PLANNING APPLICATION CONSULTATION RESPONSE

Application Number:	3/2022/1116
Proposal:	Discharge of Condition 9 (Drainage Scheme) of planning application 3/2019/1104.
Location:	Land at Hawthorne Farm, Hawthorne Place, Clitheroe, BB5 2HU

Lead Local Flood Authority Position

Project Name:
HAWTHORNE FARM CLITHEROE
 Client:
PERSIMMON HOMES
 Designed: **D.A.** Drawn: **D.A.** Checked: **R.A.** Scale: **1:250**
DRAINAGE LAYOUT
 Project No:
19310
 Drawing No:
19310-EDGE-XX-XX-DR-C-C2001 P18
PRELIMINARY NOT FOR CONSTRUCTION

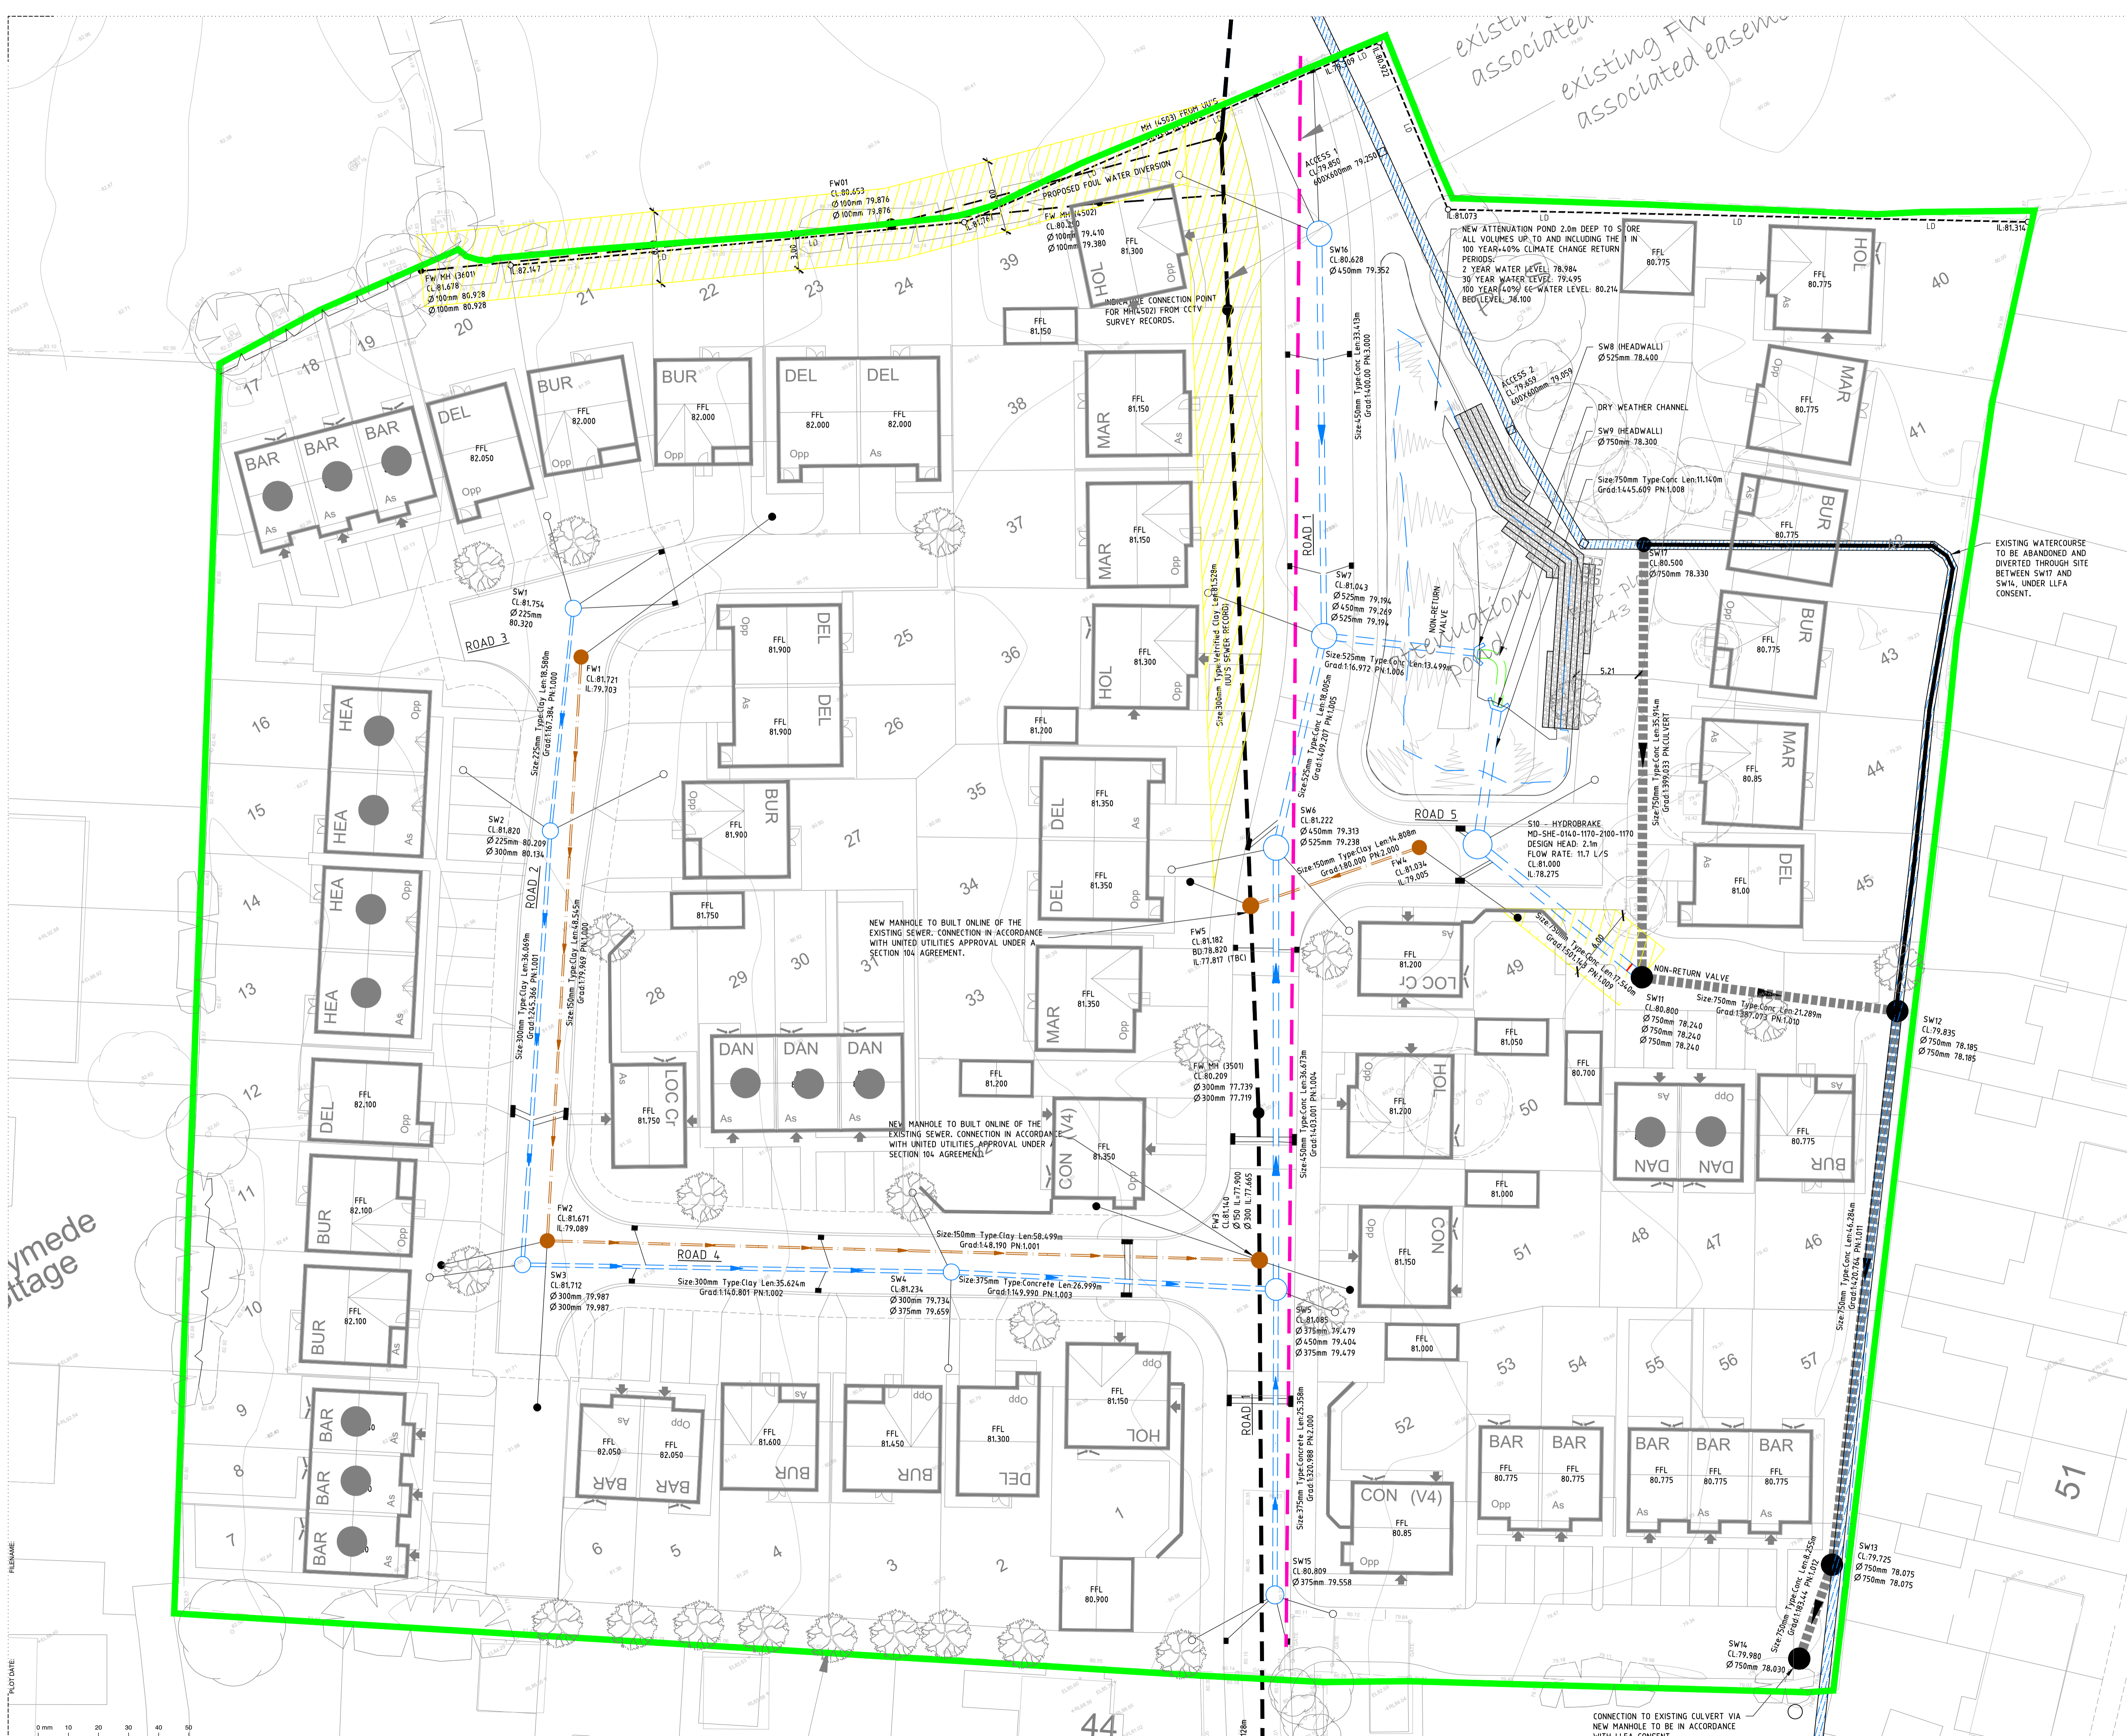
The Lead Local Flood Authority acknowledges the submission of the contributing area plan and the corresponding the contributing impermeable area (ha) section within the calculations showing the addition of the urban creep allowance, final note is made to a potential discrepancy of pipe reference 1.002 which has a contributing area of

1390.819m² and therefore a final contributing area of 0.152ha after the urban creep allowance has been applied, however the calculations show an impermeable area of 0.140ha.
